KITTITAS COUNTY

DEPARTMENT OF PUBLIC WORKS

MEMORANDUM

TO: All Staff
FROM: Public Works Plan Review Team
DATE: August 5, 2026
SUBJECT: AU-26-00008 Sellers

SHEET TITLE:
SITE PLAN / COVER

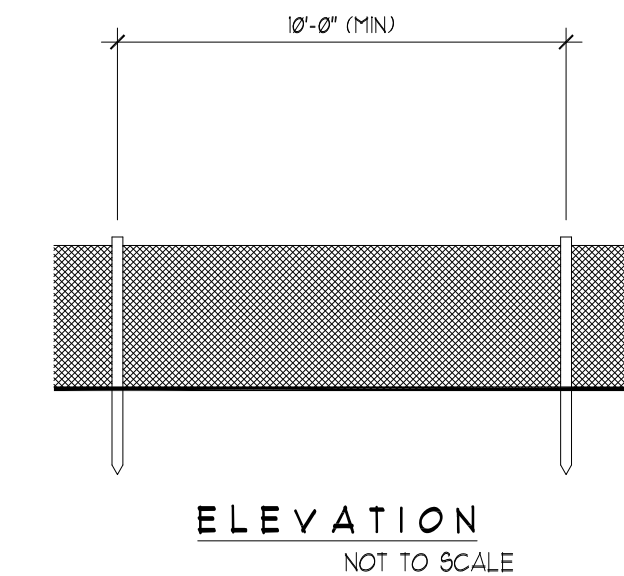
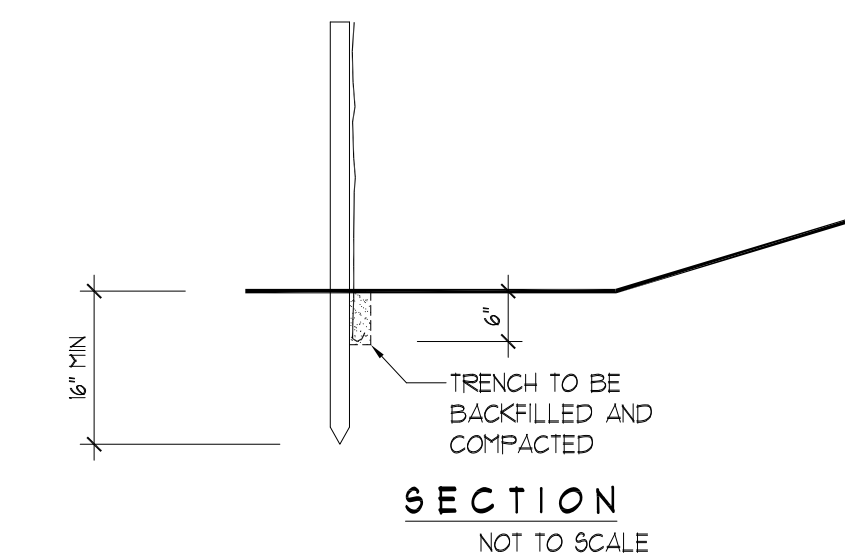
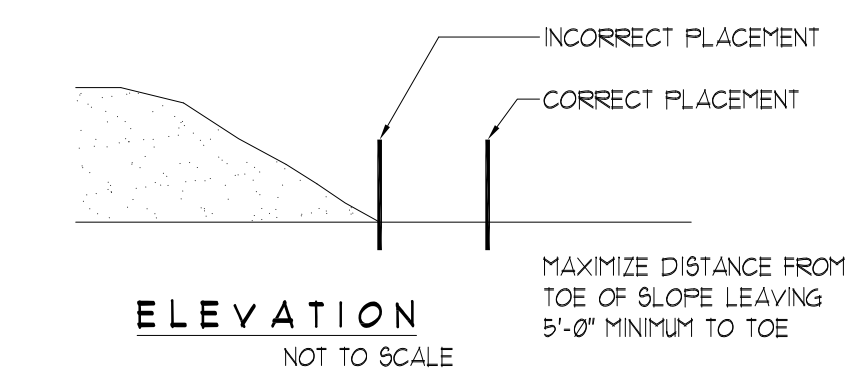
ACCESS	1. Issued Access Permit AC-26-00058 for ADU, driveway must meet conditions of permit and inspection is required prior to occupancy. 2. An approved access permit shall be required from the Kittitas County Department of Public Works prior to creating any new driveway access or altering an existing access. 3. Maintenance of driveway approaches shall be the responsibility of the owner whose property they serve. The County will not maintain accesses. 4. Any further subdivision or lots to be served by proposed access may result in further access requirements. See Kittitas County Road Standards. In addition to the above-mentioned conditions, all applicable Kittitas County Road Standards apply to this proposal. Access is not guaranteed to any existing or created parcel on this application.(RC)
ENGINEERING	Except as exempted in KCC 14.05.060, no grading or filling upon a site involving more than one hundred (100) cubic yards shall be performed without a grading permit from the County Engineer or Public Works designee (KCC 14.05.050). An application for grading in excess of five hundred (500) cubic yards shall be accompanied by an engineered grading plan (KCC 14.05.080). (CBP)
